**WELWYN HATFIELD BOROUGH COUNCIL
EXECUTIVE DIRECTOR - PLANNING, PUBLIC PROTECTION AND GOVERNANCE**

DELEGATED APPLICATION

Application No: 6/2021/2526/HOUSE
Location: 379 St Albans Road West Hatfield AL10 9RU
Proposal: Erection of a single storey rear extension, a two storey rear, front and side extension, a roof extension and insertion of a rear box dormer.
Officer: Ms Kirsty Shirley

Recommendation: Refused

SCALE	1:100 @ A3
DATE	20210721
DRAWN	SDJ
DRAWING No	301

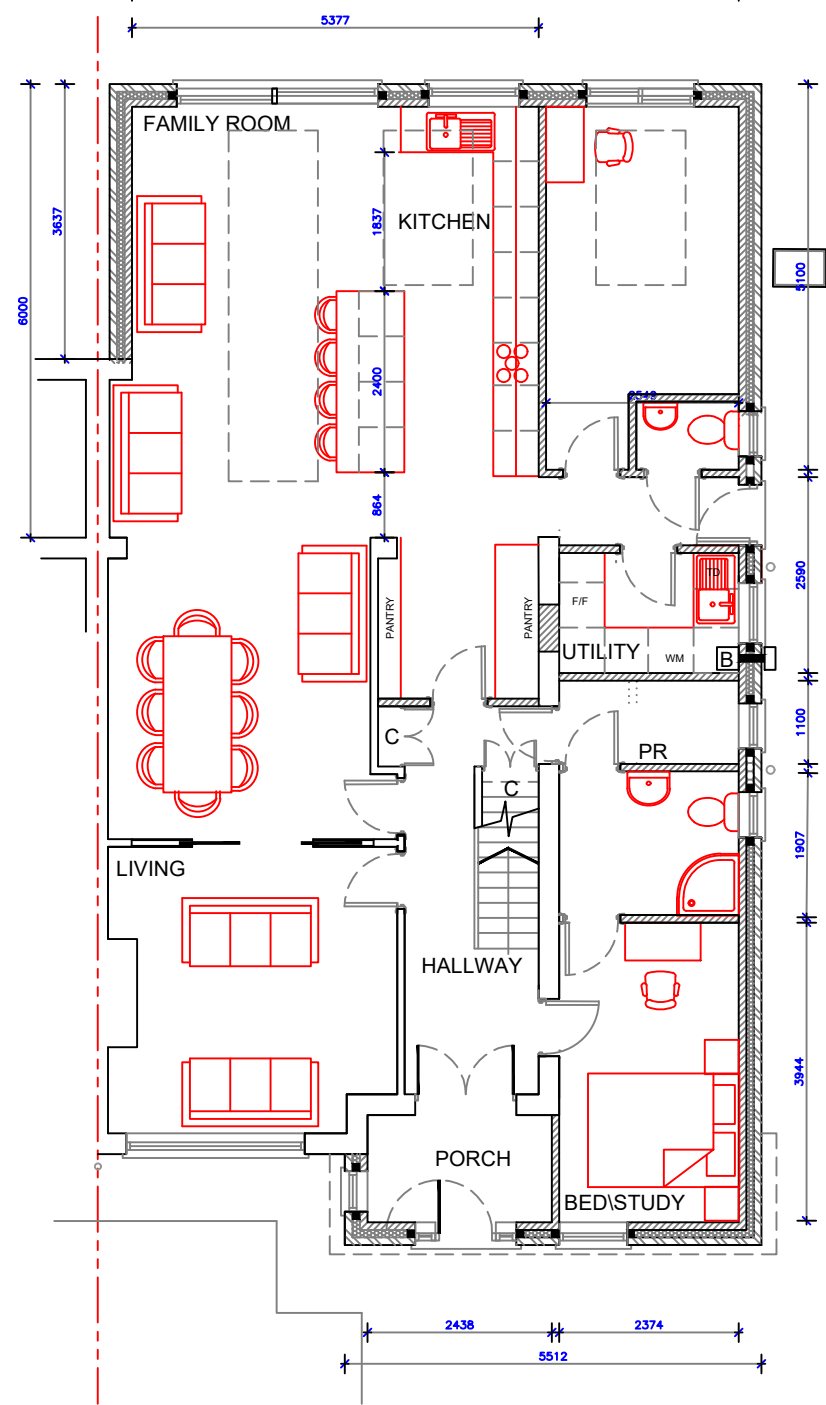
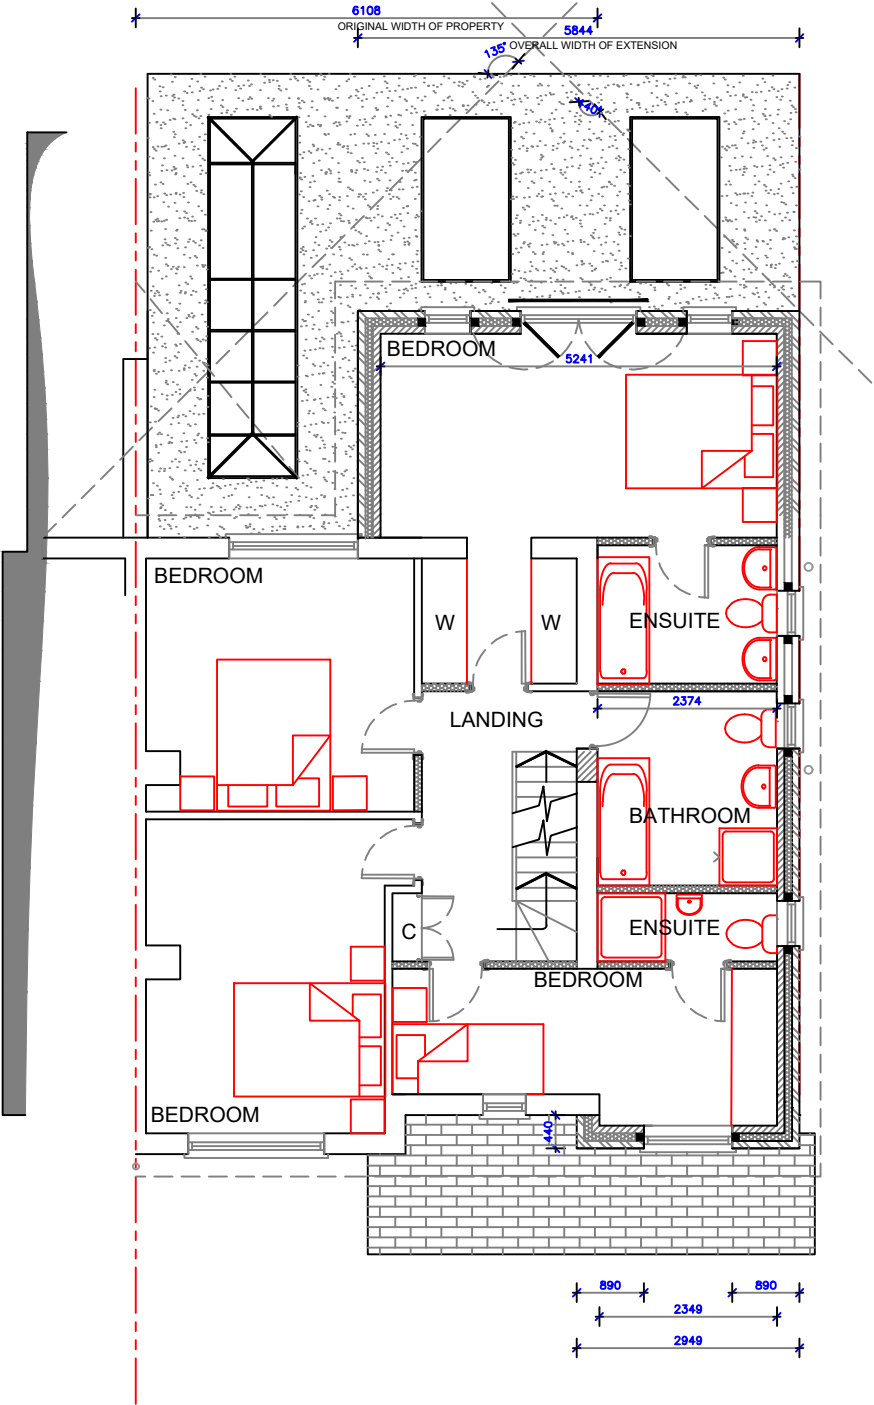
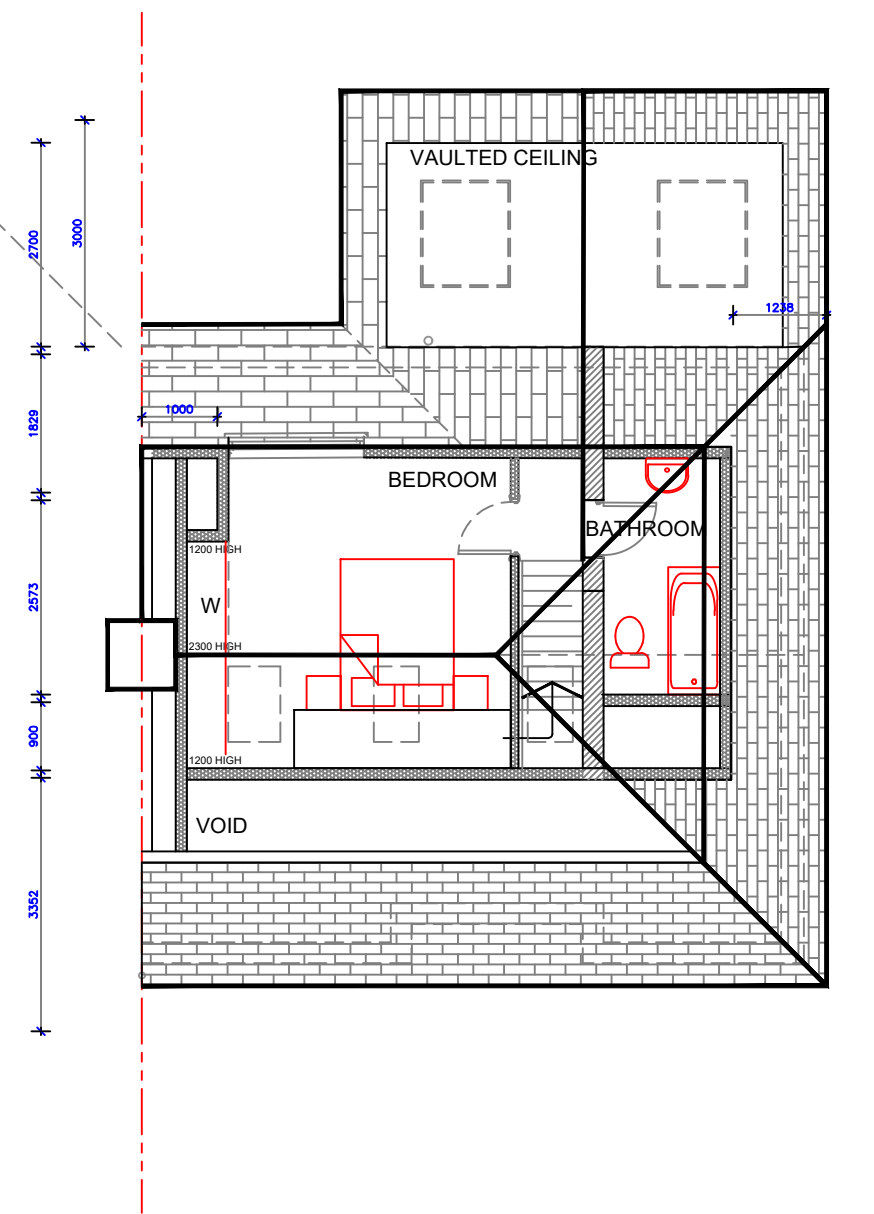
<p>Impact on neighbours</p>	<p>Policy D1 of the District Plan and the SDG state that any extension should not cause loss of light or appear unduly dominant from an adjoining property or result in a detrimental loss of privacy. Policy SADM11 of the Emerging Plan aims to preserve neighbouring amenity. The most impacted neighbours would be those located to either side of the application site (No. 377 and No. 381 St Albans Road West).</p> <p>Objections have been received from neighbours in regards to loss of light and privacy, and the proposal's overbearing impact.</p> <p>The proposal of the previous application 6/2021/1107/HOUSE was considered too broadly comply with Policy D1 of the District Plan; the Supplementary Design Guidance and NPPF in relation to maintaining the living conditions of any neighbours.</p> <p>In this case, reduction in scale of the proposal compared to previous application 6/2021/1107/HOUSE, alongside the removal of one window in the flank elevation of the application dwelling, would ensure that the development would still comply with Policy D1 of the District Plan; the Supplementary</p>

Design Guidance and NPPF in relation to maintaining the living conditions of any neighbours.
Access, car parking and highway considerations	<p>As the proposed extension would increase the number of bedrooms at the property from three to five and involve the loss of the existing garage, it is important that the Council Parking SPG and Interim Parking Standards are considered. Given the location of the application site and the number of bedrooms proposed it is considered that the development should seek to provide three off street car parking spaces in this case.</p> <p>The front of the property already benefits from a large area of hardstanding at the frontage that allows for the parking of at least three parking spaces. Furthermore, the size of the existing garage falls below the minimum space dimensions set out in Council's Interim Parking Standard and is therefore considered inadequately sized for many modern cars. As such there are no objections raised in terms of parking.</p>

DRAWING TITLE
Proposed Extension
Elevations
Proposed

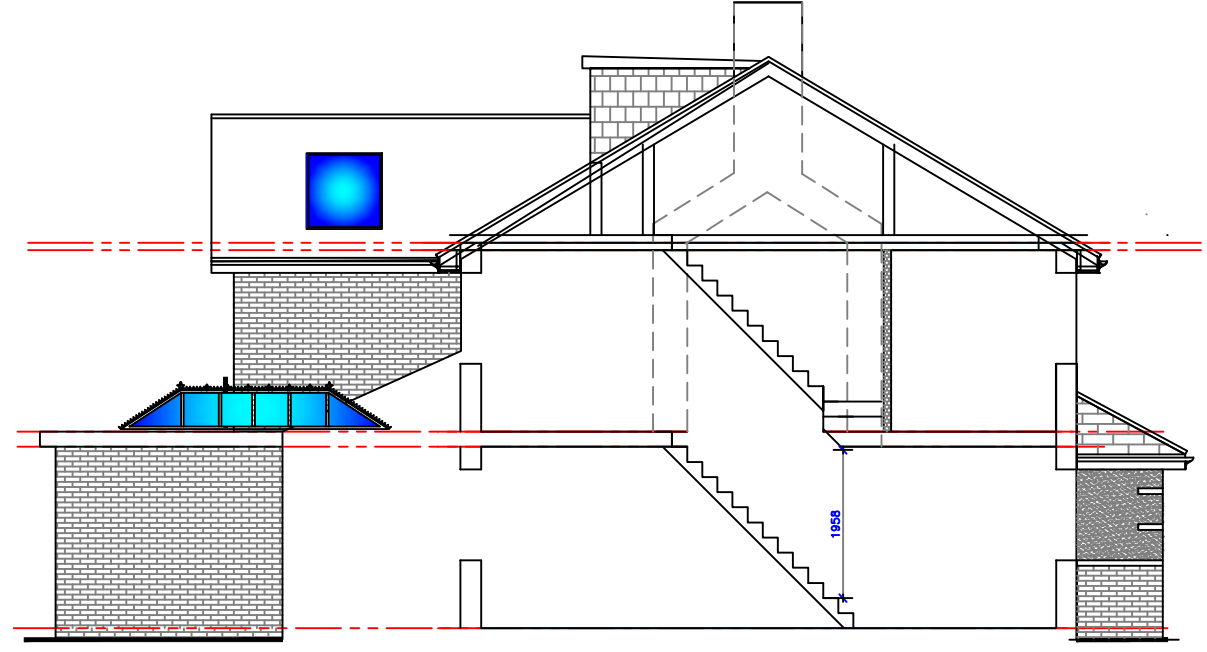
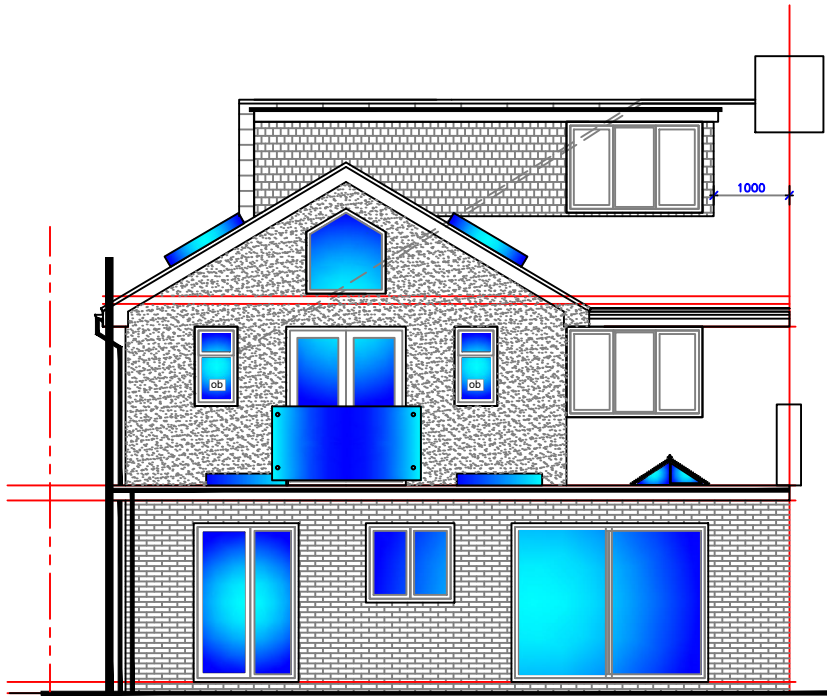
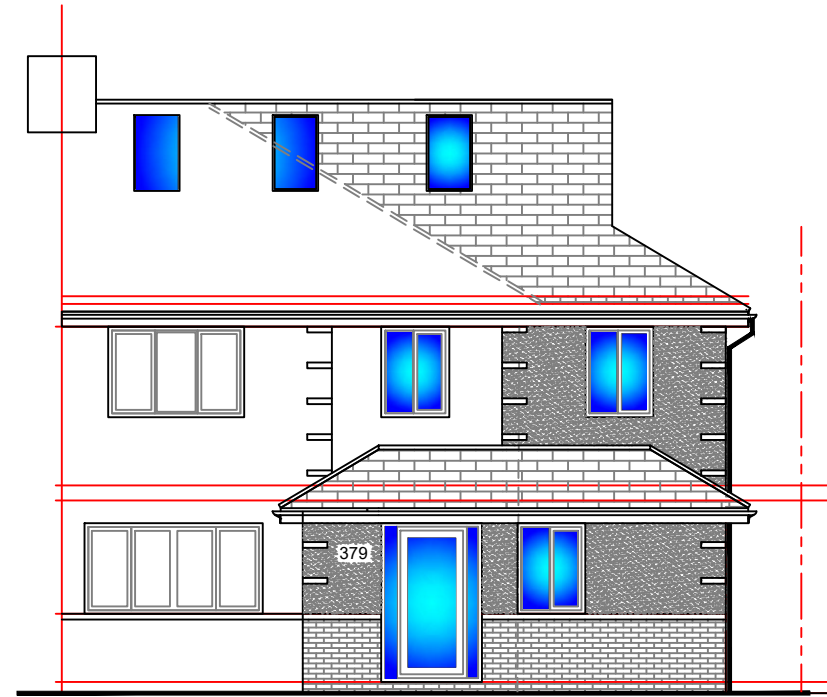
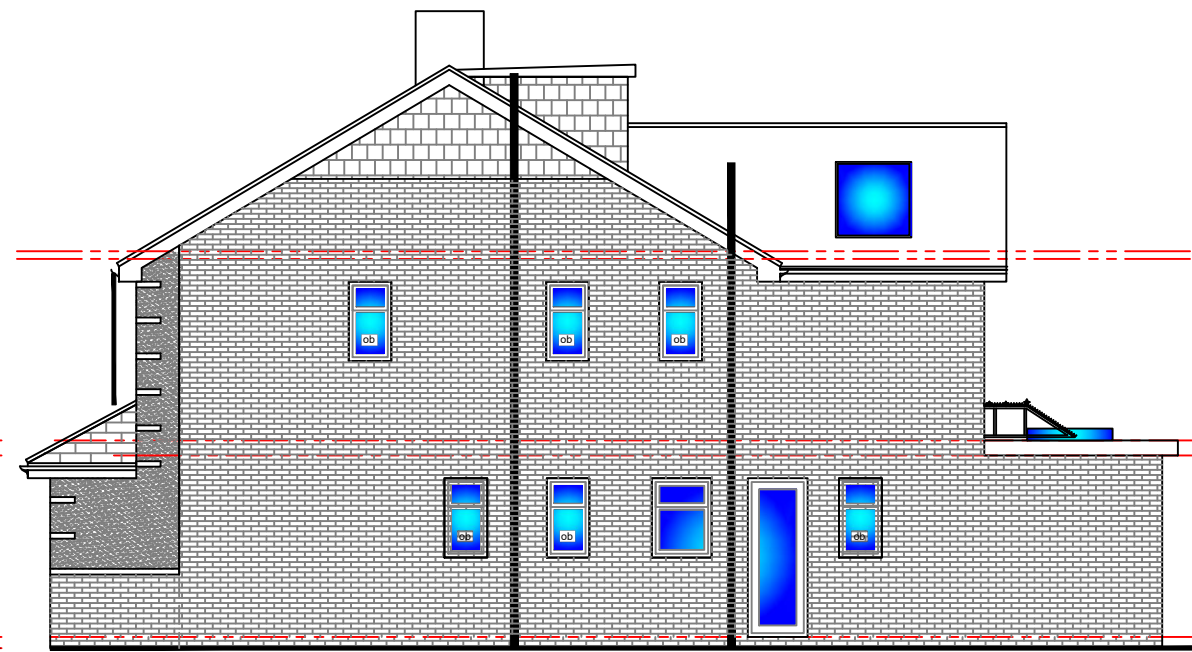
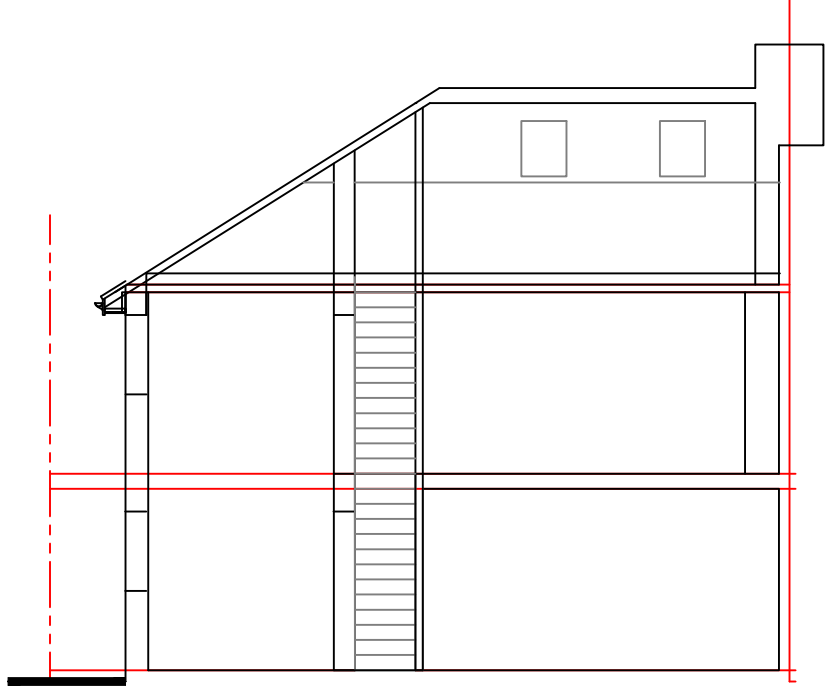
Main Issues	
<p>Design (form, size, scale, siting) and Character (appearance within the streetscene)</p>	<p>The National Planning Policy Framework (NPPF) chapter 12 emphasises the importance of good design as a key aspect of sustainable development. Paragraph 126 advises that the creation of high quality buildings and places is fundamental to what the planning and development process should achieve and that good design is a key aspect of sustainable development. Paragraph 130 the NPPF further advises that decisions should ensure developments will function well, be visually attractive, sympathetic to local character and establish a strong sense of place. Paragraph 134 is clear that “development that is not well designed should be refused, especially where it fails to reflect local design policies and government guidance on design, taking into account any local design guidance and supplementary planning documents such as design guides and codes”.</p> <p>District Plan Policy GBSP2 of the Welwyn Hatfield District Plan notes that development within the specified settlements will be limited to that which is compatible with the maintenance and enhancement of their character. Policies D1 and D2 aim to ensure a high quality of design and to ensure that development respects and relates to the character and context of the locality, maintaining and where possible enhancing the character of the existing area. These policies are expanded upon in the Council’s Supplementary Design Guidance (SDG) which requires the impact of a development to be assessed giving regard to the bulk, scale and design of the proposal and how it harmonises with the existing building and area.</p> <p>This application seeks to overcome the previous refusal reason for application 6/2021/1107/HOUSE. Application 6/2021/1107/HOUSE was refused on the basis of the proposals design, scale, form which would result in the proposal to appear visually over dominant towards the application dwelling and would subsequently fail to respect and relate to the character of the street scene.</p> <p>This application is a resubmission of the previously refused scheme, but with amendments. These amendments include a reduced the width of the proposed rear dormer, change in roof form, omission of the first floor front extension and subsequently altering the roof form on the now single storey front extension.</p> <p>The proposed roof form of the dwelling would create an unusual roof which appears gabled at the top and then at a lower level would extend outwards in a hipped form. The street scene is characterised by hipped roofs and the proposed roof form would appear visually unbalanced in its semi-detached pairing as well as detracting and discordant within the wider street scene.</p> <p>The dormer window proposed in application 6/2021/1107/HOUSE did not meet the SDG’s guidance of being set in 1m from the flank elevation, nor was the previous dormer considered to be a subservient addition within the existing roof slope.</p> <p>Due to the proposed roof form in this application, the width of the dormer has been reduced and setback 1m from the boundary of adjoining neighbour No. 377. However, the positioning of the proposed dormer within the roof remains contrary to the SDG’s guidance of being set in 1m from the flank elevation with less than 1m between the dormer cheek and flank elevation. Although the proposed dormer remains set down from the ridge and back from the eaves, given the excessive extent to which the dormer window spans across the roof slope, the dormer window would not be considered a subservient addition</p>

<p>within the existing roof slope.</p> <p>The proposed single storey front extension's limited height and projection would appear subordinate towards the application dwelling and the crown roof of the front extension would appear in keeping with the characteristic hipped roofs of the area. Single storey front extensions are common within the street scene and it is not considered that the proposed front extension would result in a marked change in the character and appearance of this row of semi-detached properties.</p> <p>The proposed two storey element of the rear extension is still considered to be excessive in scale, as the width of the extension would remain greater than that of the existing two storey part of the dwelling and consequently the rear extension is considered to be excessive in scale and overbearing towards the existing dwelling.</p> <p>In terms of the detailed character of the development, the size, proportions and appearance of the doors and window being proposed is not, on balance, considered to harm the appearance of the dwelling or the character of the area. It is also proposed to utilise materials that would match the existing property which could be secured via condition in the event of an approval. This does not however overcome the harm in relation to the bulk and design of the proposals identified above.</p> <p>It is considered that amendments to the proposal within this application compared to previous application 6/2021/1107/HOUSE would still result in the proposed extensions to overwhelm and dominate the existing dwelling. The proposal would continue to fail to respect the character of the area and subsequently has not overcome previous refusal reason 1.</p> <p>Consequently, it is considered that the proposed development is excessive and of a poor standard of design that is contrary to the NPPF and Policies GBPS2, D1 and D2 of the District Plan which attach great importance to the design of the built environment and the SDG which seeks a design led approach to development.</p>

1. The proposal would result in visually over dominant additions to the dwelling which fails to reflect the design and character of the property, which would be detrimental to the character of the streetscene. Accordingly the proposal represents a poor standard of design that would be contrary to policies D1 and D2 of the Welwyn Hatfield District Plan; the Supplementary Design Guidance; and the National Planning Policy Framework.
